Response to Report by Galway County Council

Cooloo Wind Farm (ACP
Ref. 323761)

MKO has prepared a response, on behalf of Neoen Renewables Ireland Ltd. (the Applicant), to the report received from Galway County Council (GCC), as requested by An Coimisiún Pleanála (the Commission, ACP) on 13th January 2026 in relation to the Strategic Infrastructure Development (SID) planning application before them for consideration (ACP Ref: 323761).

Figure 15-6b Proposed cable route and potential diversion routes

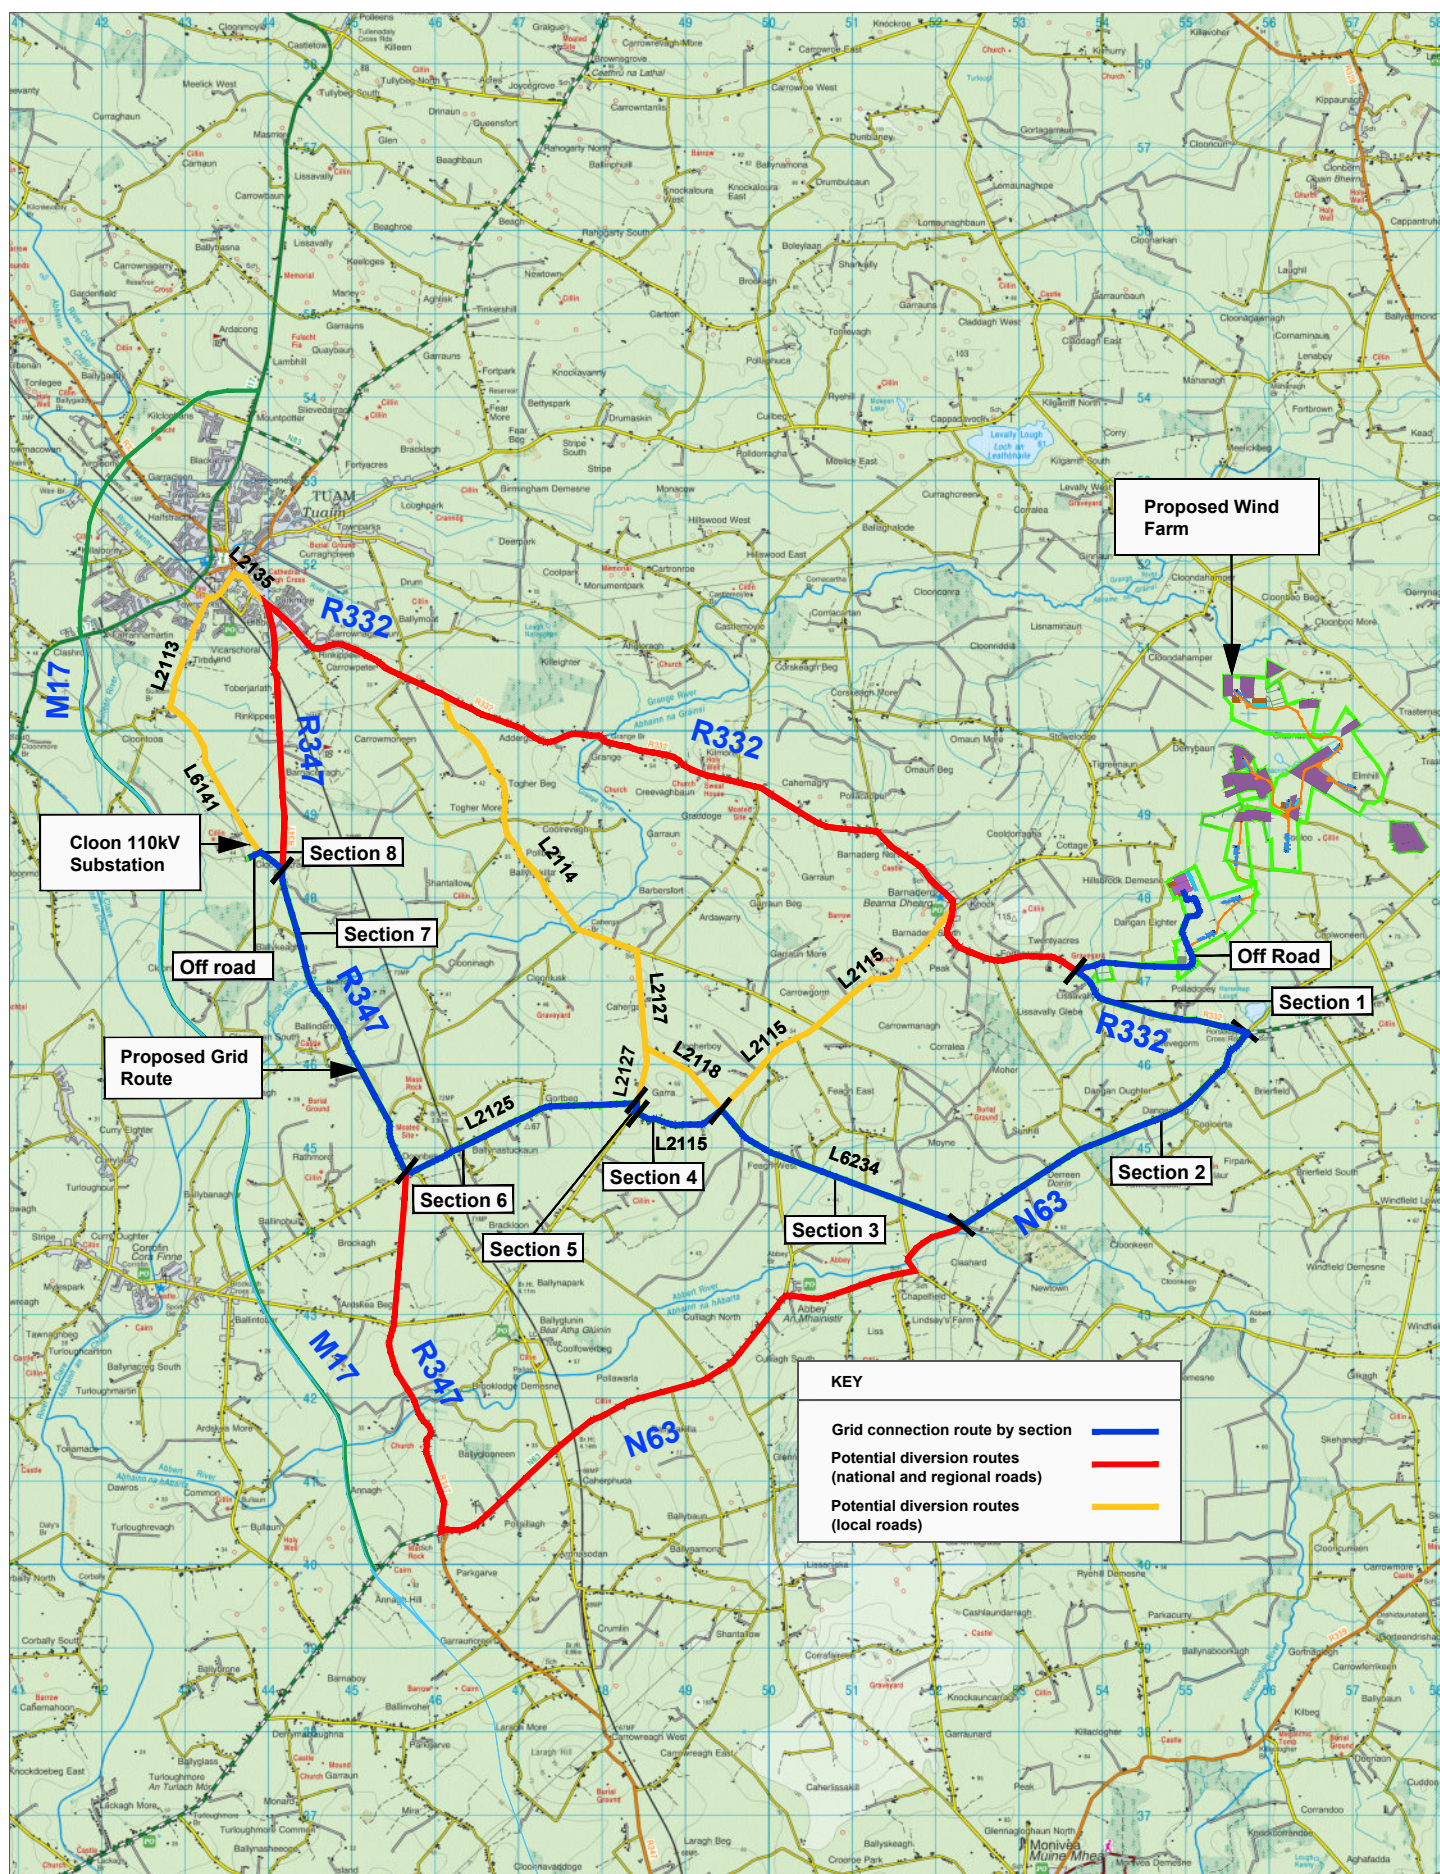
- iii. *Whilst having regard to the safety and the impact to the public road in accordance to DM Standard 33a of the Galway County Development Plan 2022-2028, where the uncertainty of regional and local road network arises regarding the carrying capacity of alternative traffic diversions to support such extensive road closures, in conjunction with the necessity of scoping and seeking third party consent of proposed grid connection underground works where impacting the public road circa 18.0km of works from Subject site to Cloon Substation as proposed & whereby considered outside the control of the applicant. It is considered that the proposed works are at variance to Policy Objectives NNR 2 in relation to safeguarding regional and local roads of the Galway County Development Plan 2022-2028. Therefore, in relation to safeguarding the transport function of public roads and associated public road junctions, it is considered that the proposed development works would interfere with the safety and endanger public safety by reason of traffic hazard or obstruction of road users or otherwise and therefore would be contrary to the proper planning and sustainable development of the area*

The details of traffic effects of the construction of the Proposed Grid Connection is detailed in Section 15.1.7 of Chapter 15 of the EIAR. A majority of the route will require a road closure at the point of construction during the construction of the Proposed Grid Connection. A precautionary scenario where a road closure will be required for the entire route is assumed for the purpose of the assessment. The potential diversions identified will result in low volumes of existing traffic on local roads being diverted onto other local roads, or onto roads of a higher standard, including the N63, R332 and the R347.
